**SPRINGS AT WATERVIEW - AMENDED STORM**

GRINNELL DITCH NORTH - PLAN / PROFILE

GRINNELL DITCH SOUTH PROFILE

**STORM B PROFILE**

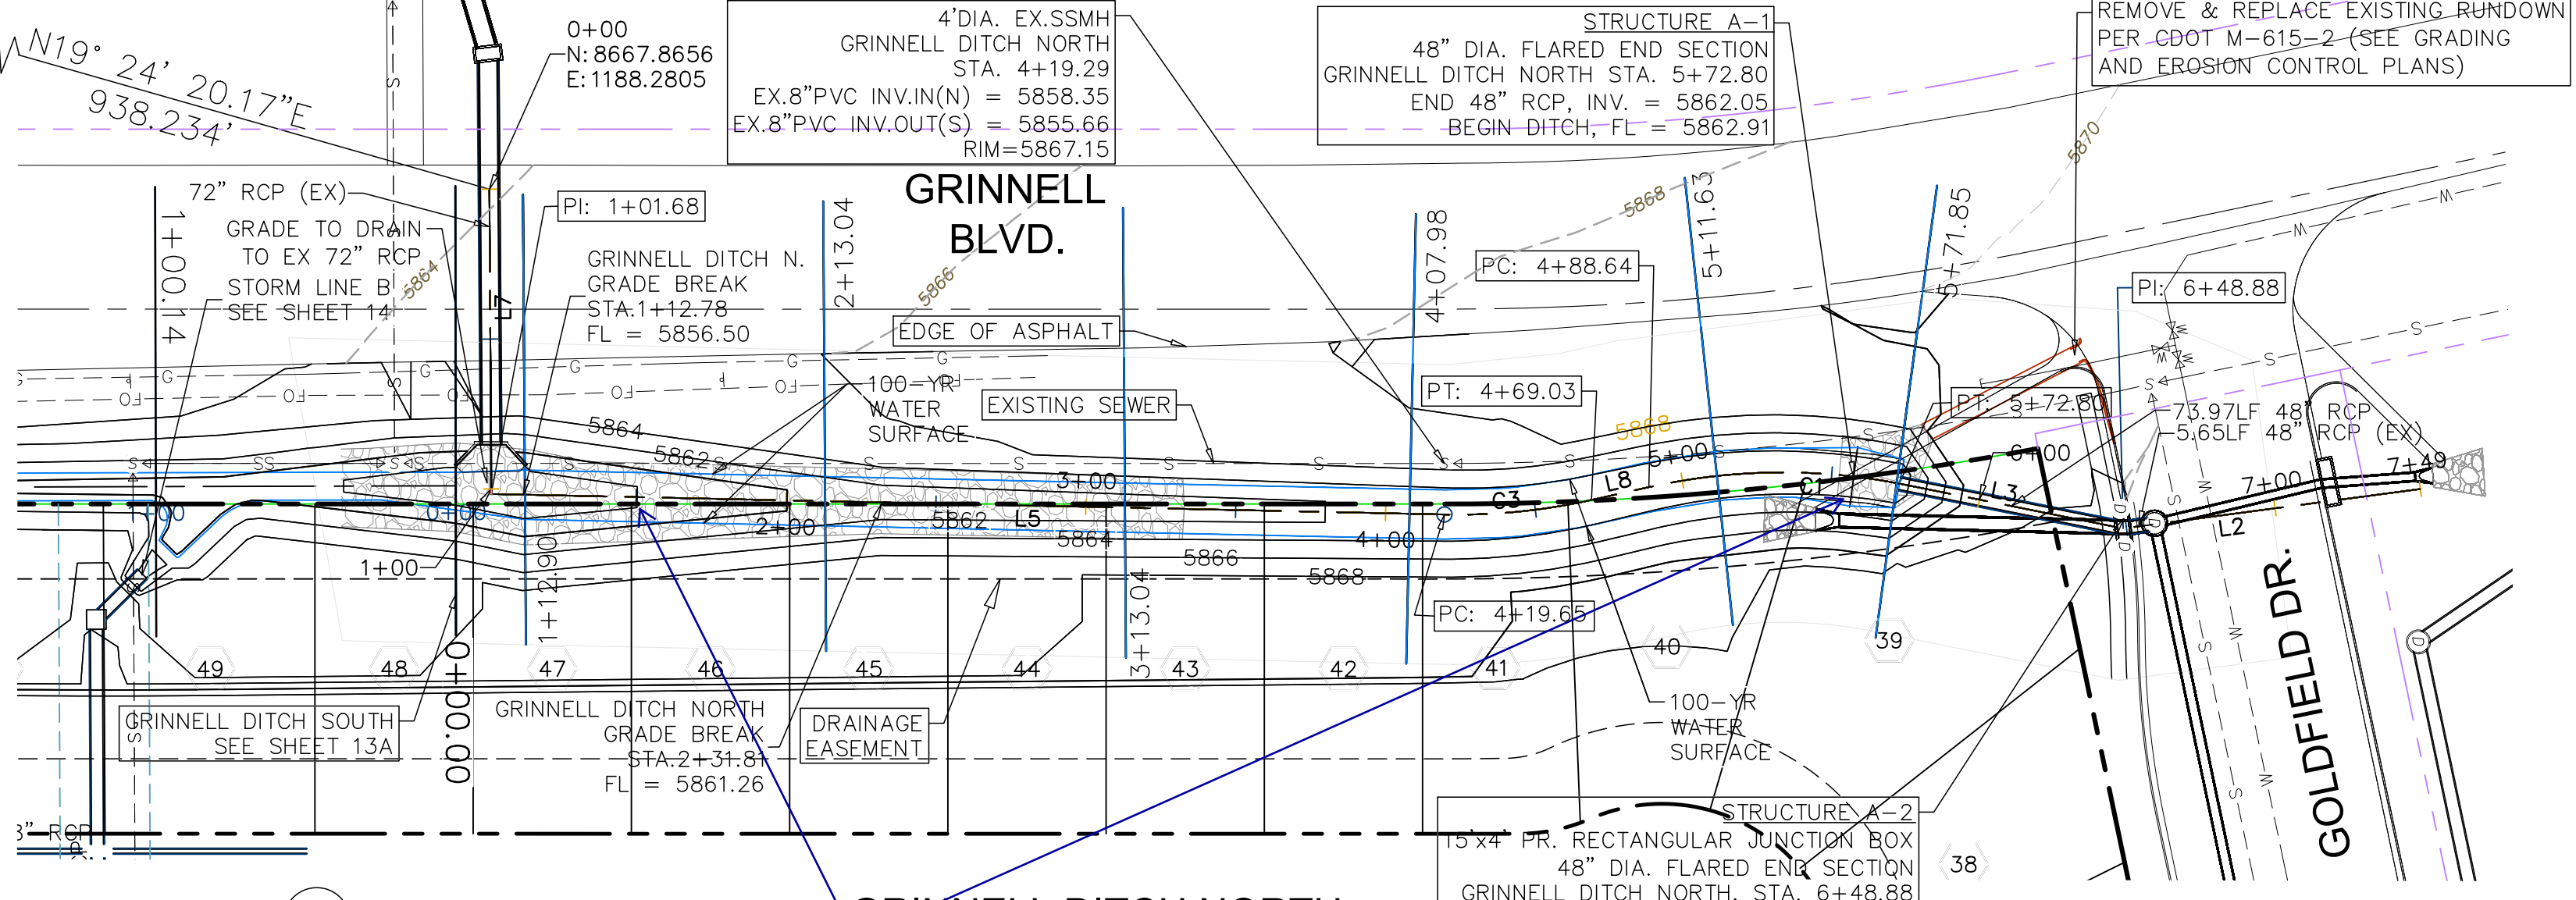
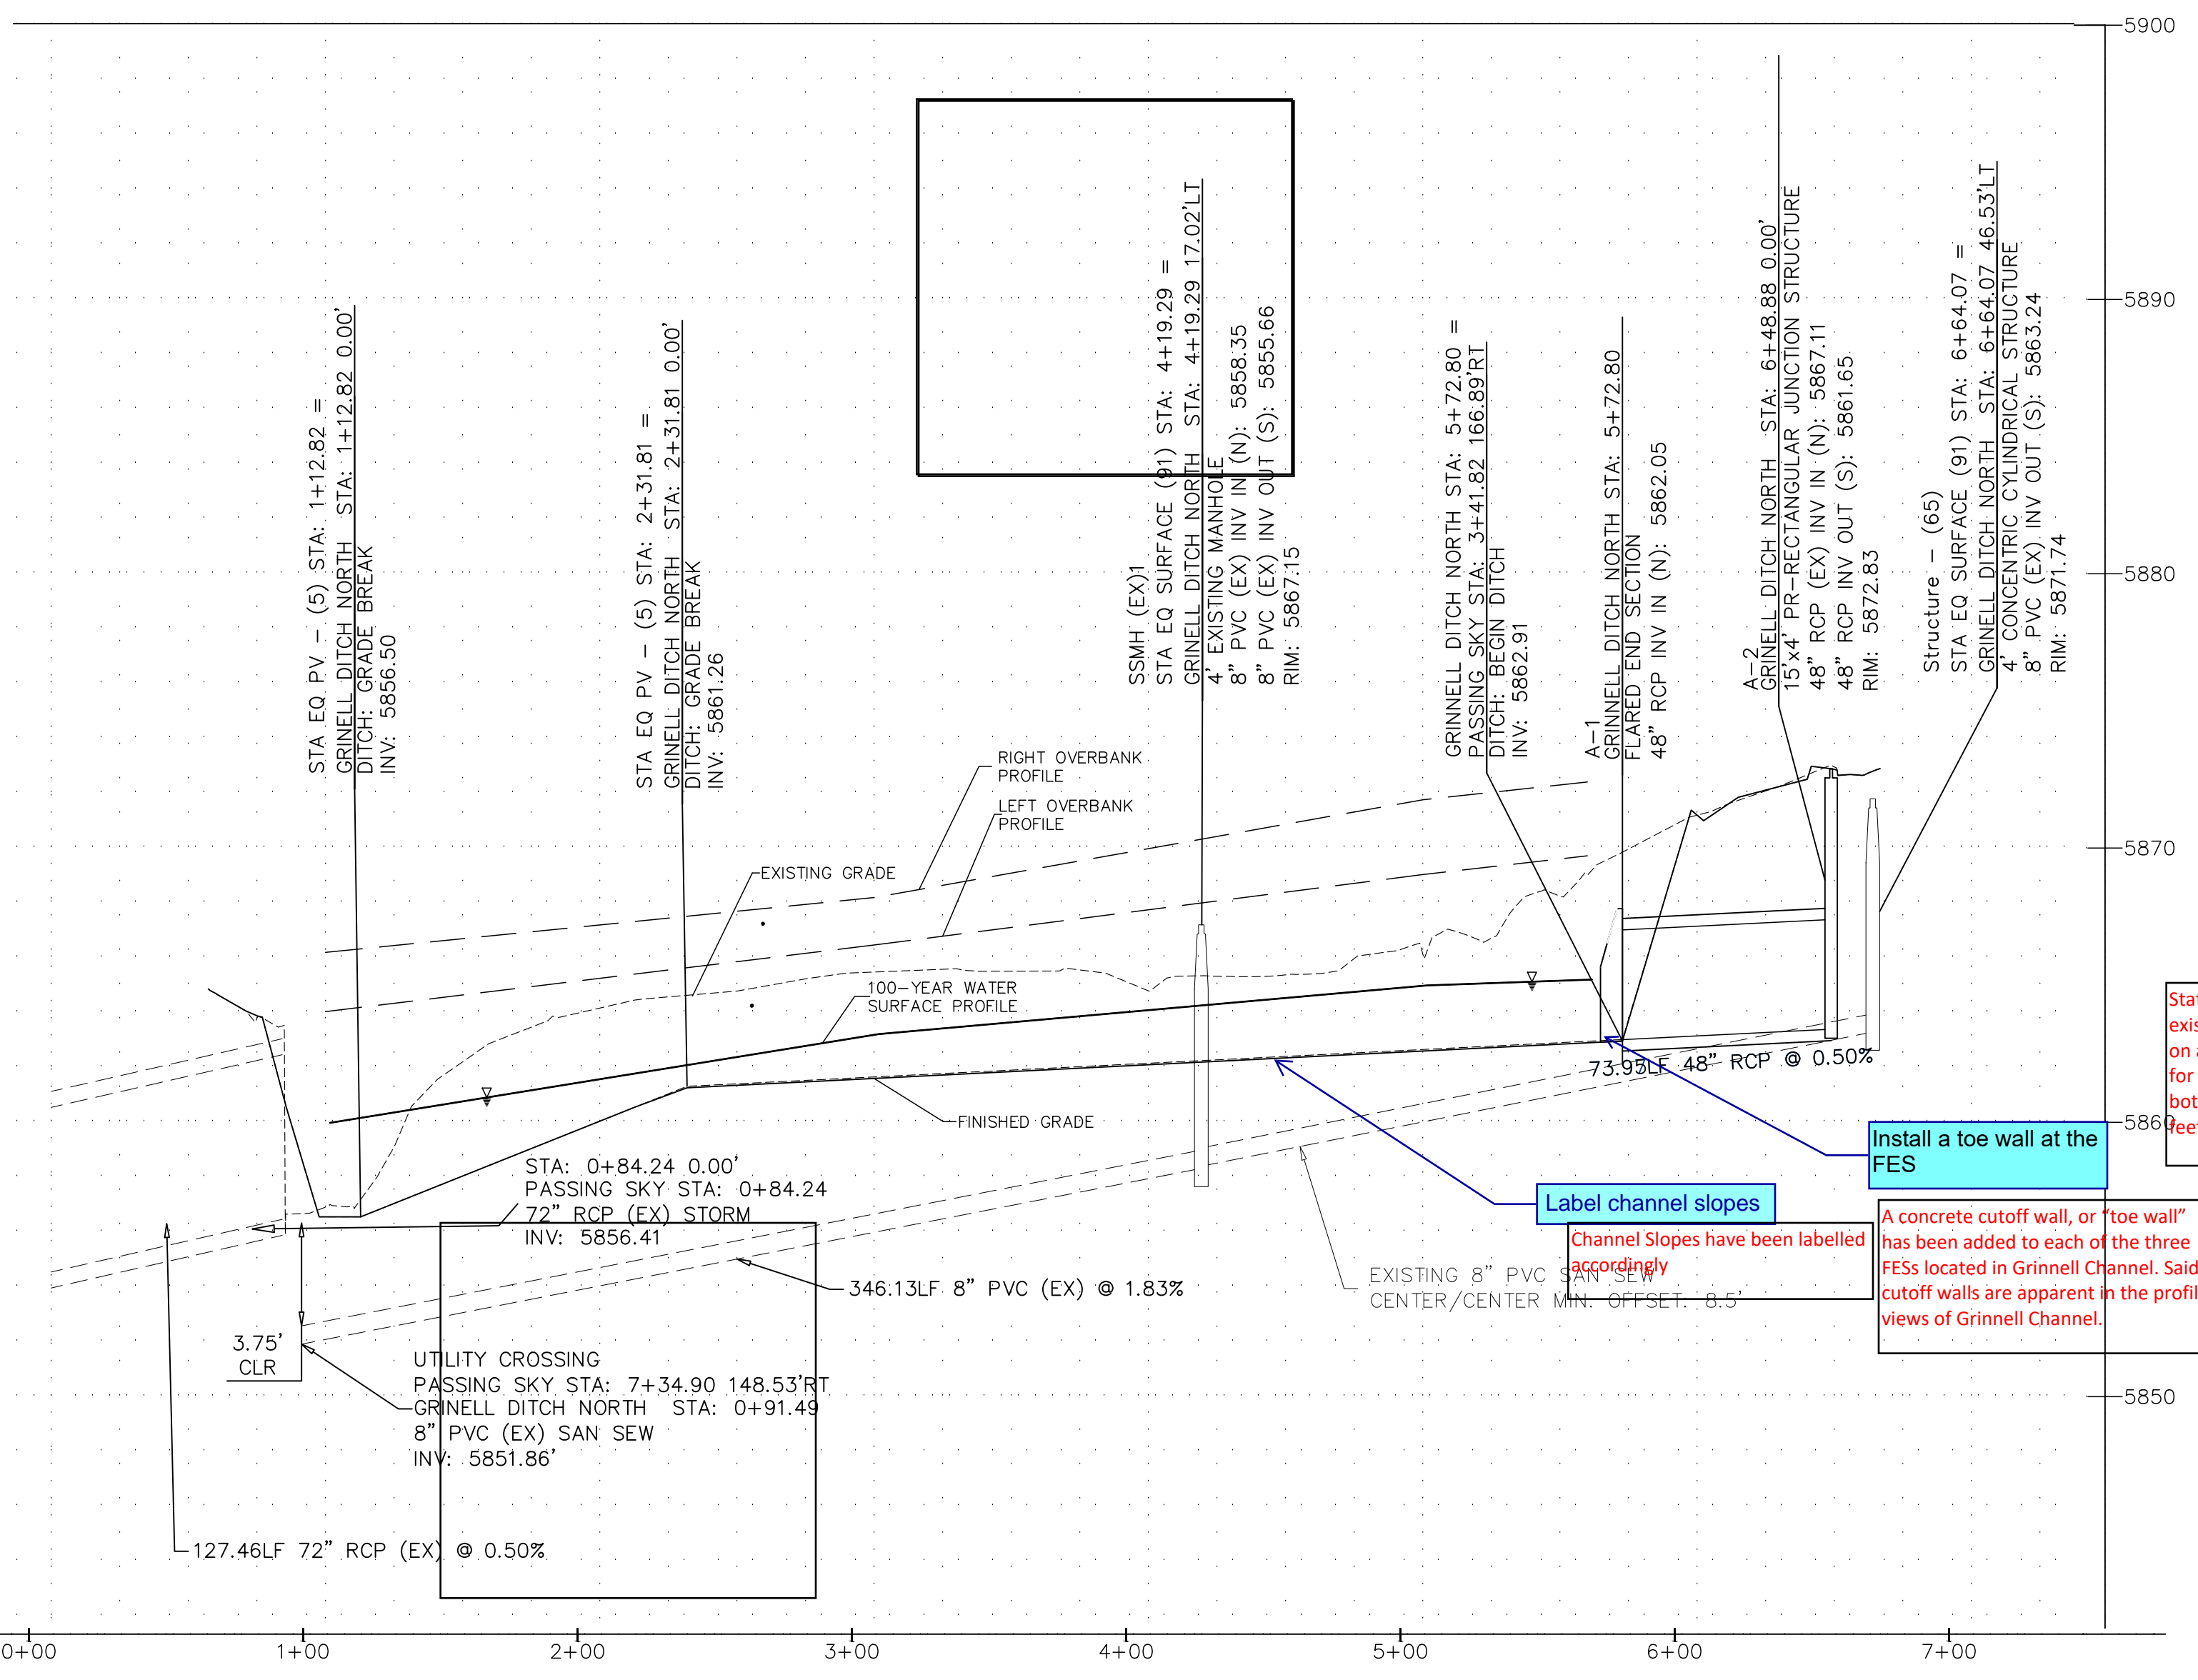
Provide riprap details. Identify the riprap type, length, width, depth. Is there a lining between the riprap and subgrade?

For all cross sections:  
- Label the station offsets of the toes.  
- Channel bottom width appears to vary  
- Label the existing and proposed grades.

Is this supposed to be the edge of asphalt. Plat only shows a property line.

Drainage easement on the plat was only 25 feet. It should be adjusted to include the entire channel side.

Install a toe wall at the FES

Label channel slopes
